KITTITAS COUNTY COMMUNITY DEVELOPMENT SERVICES

June 16, 2014

Subject: Final Planned Unit Development Application for the Ranch on Swauk Creek

Ranch on Swauk Creek
Swauk Road 'A' Segment 2.1

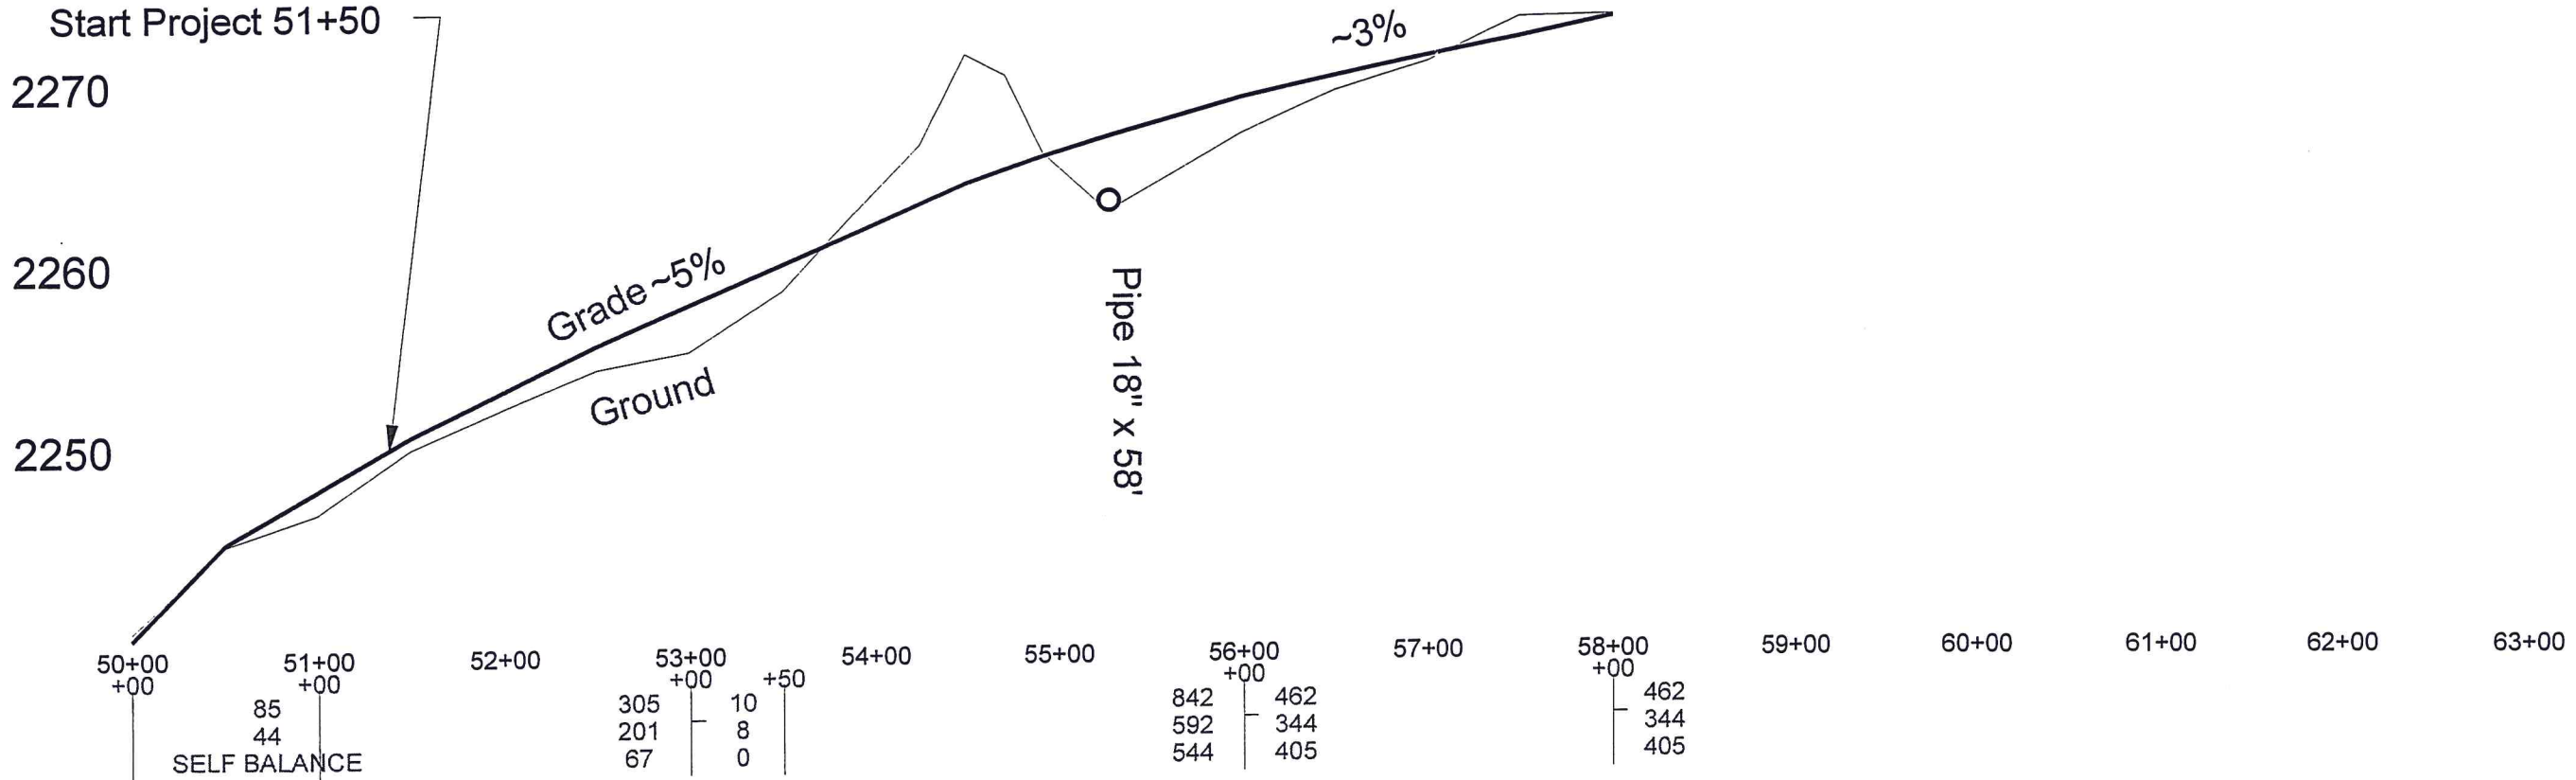
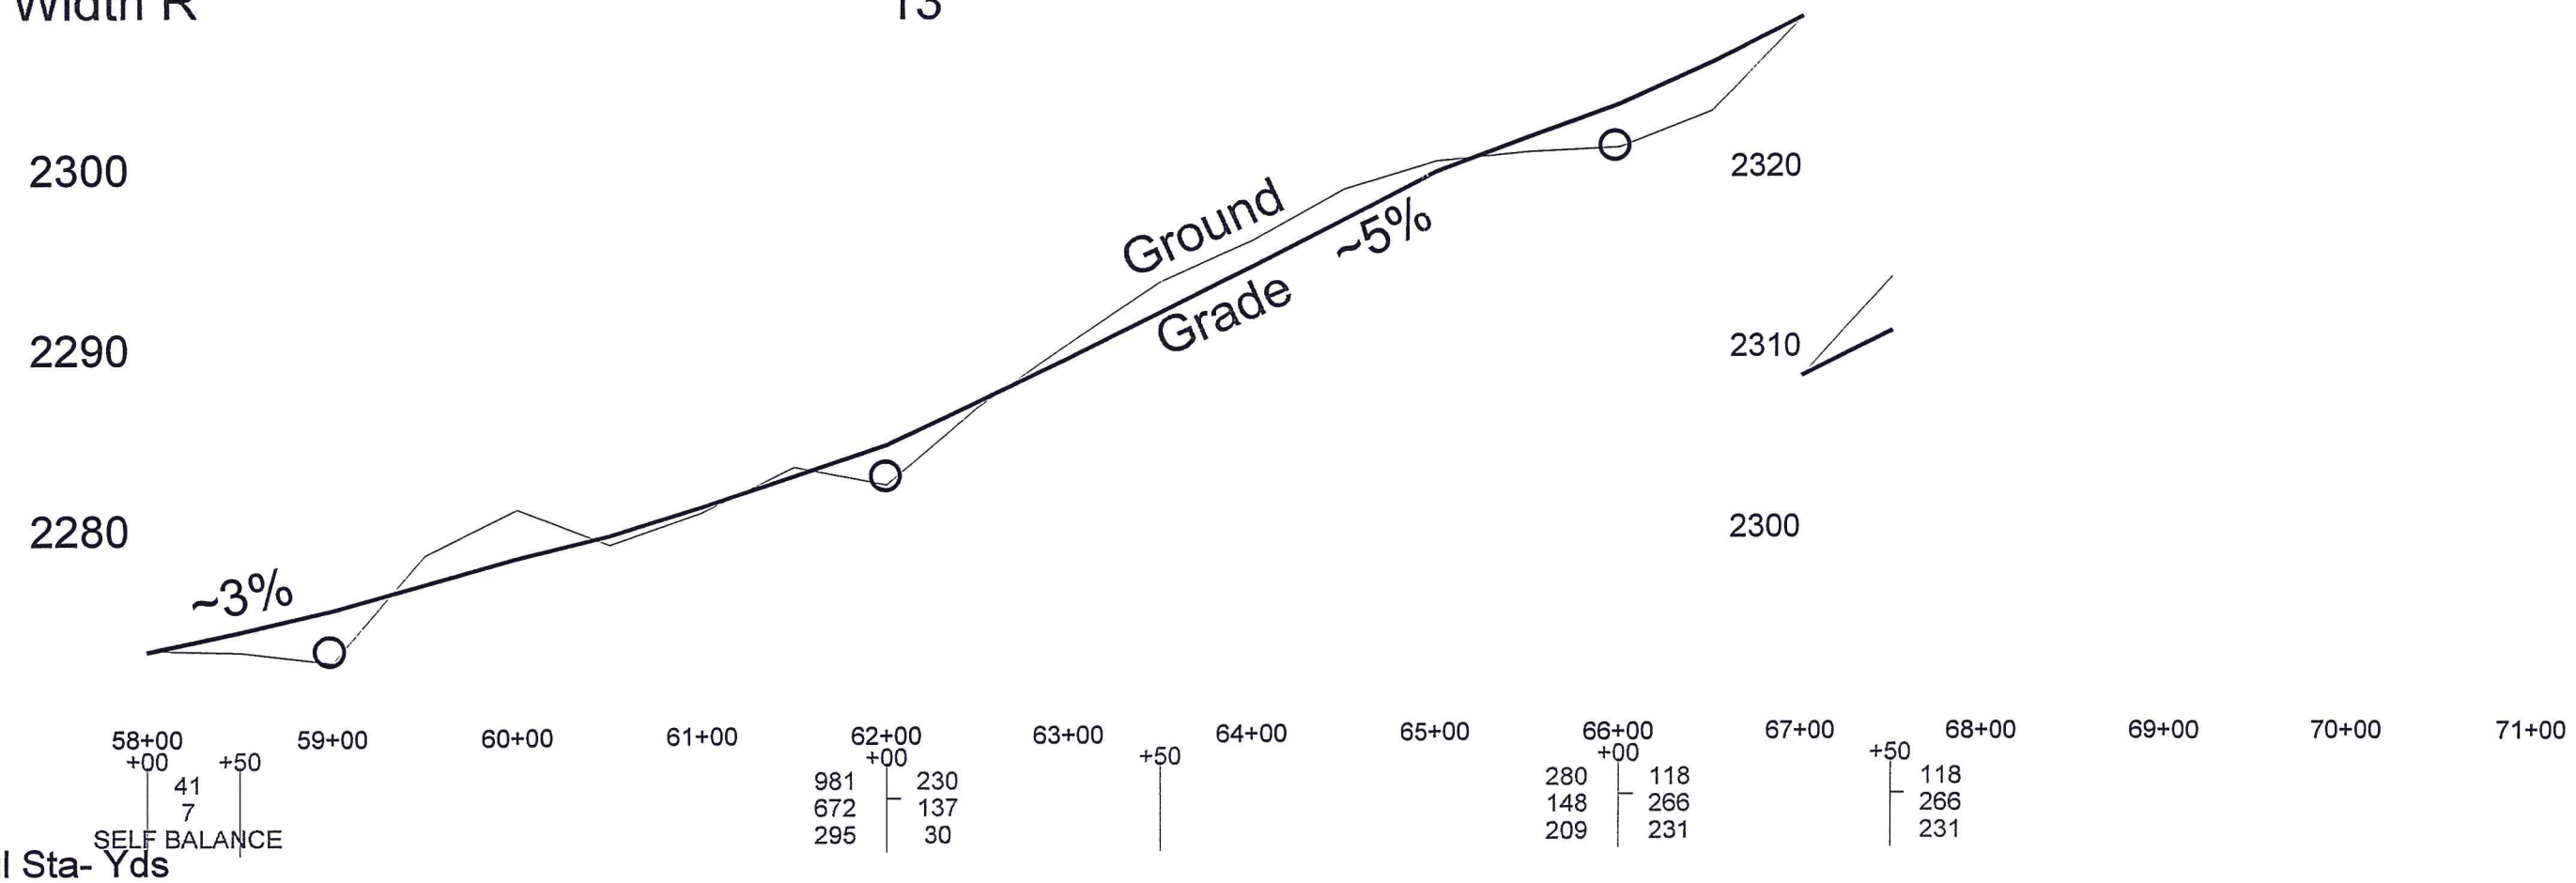
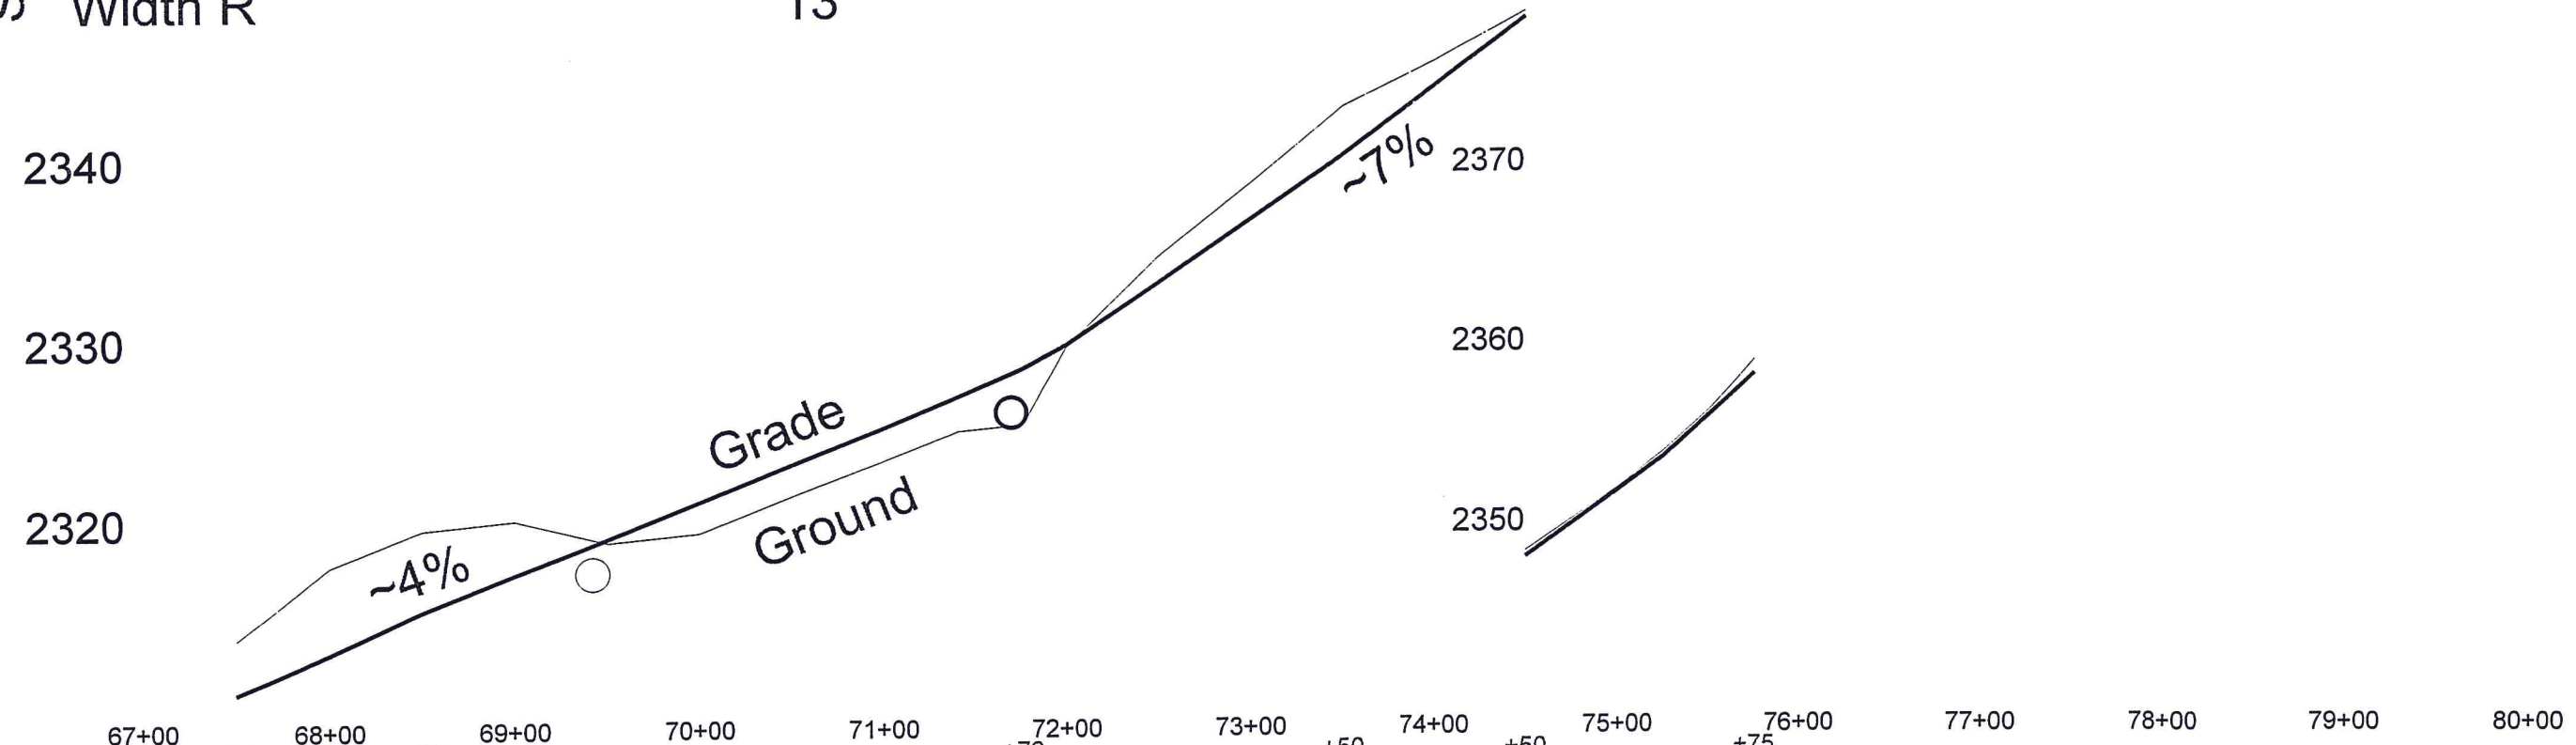
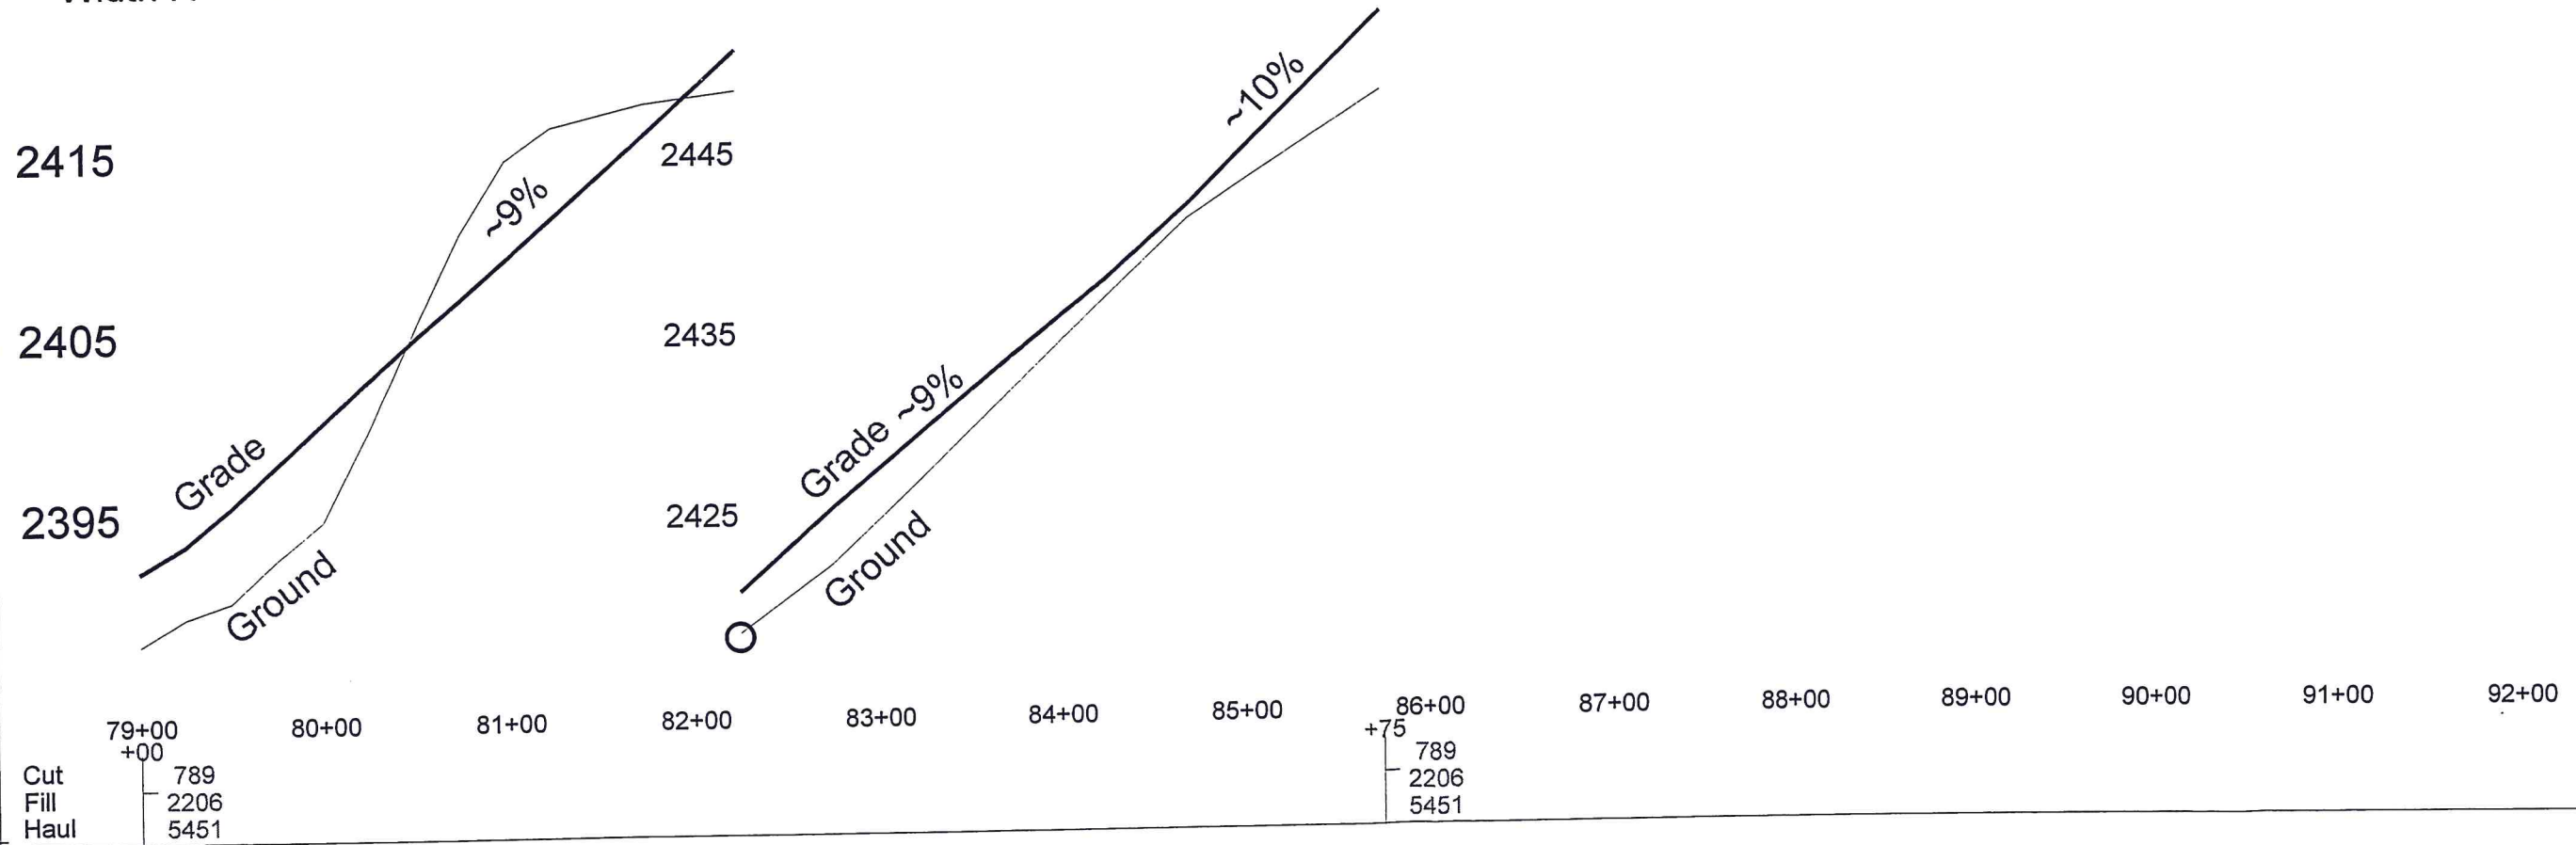
Attachment E addresses road grading but it does not appear to cover all three phases of the PUD nor does it appear on the main map required at a. At a minimum, all proposed roadways, utilities and preliminary grades for either Phase 1 (if seeking phased approval) or Phases 1-3 need to be shown on the map.

Attachment A and E are referenced in the application as being responsive to this criteria. However Attachment A is not a map, it is a narrative only. Attachment E includes roadway surfacing cost estimates but it is not clear that this covers more than Division 1 Phase 1. Further, the paved area needs to be shown on the overall PUD map exhibit, or if seeking phased approval, on the Phase 1 map exhibit.

Same as above, it is not clear that the roadways depicted in Attachment E cover only Phase 1, Division 1 or if they are intended to serve all of Phase 1's 81 lots. This needs to be shown on the required map exhibit.
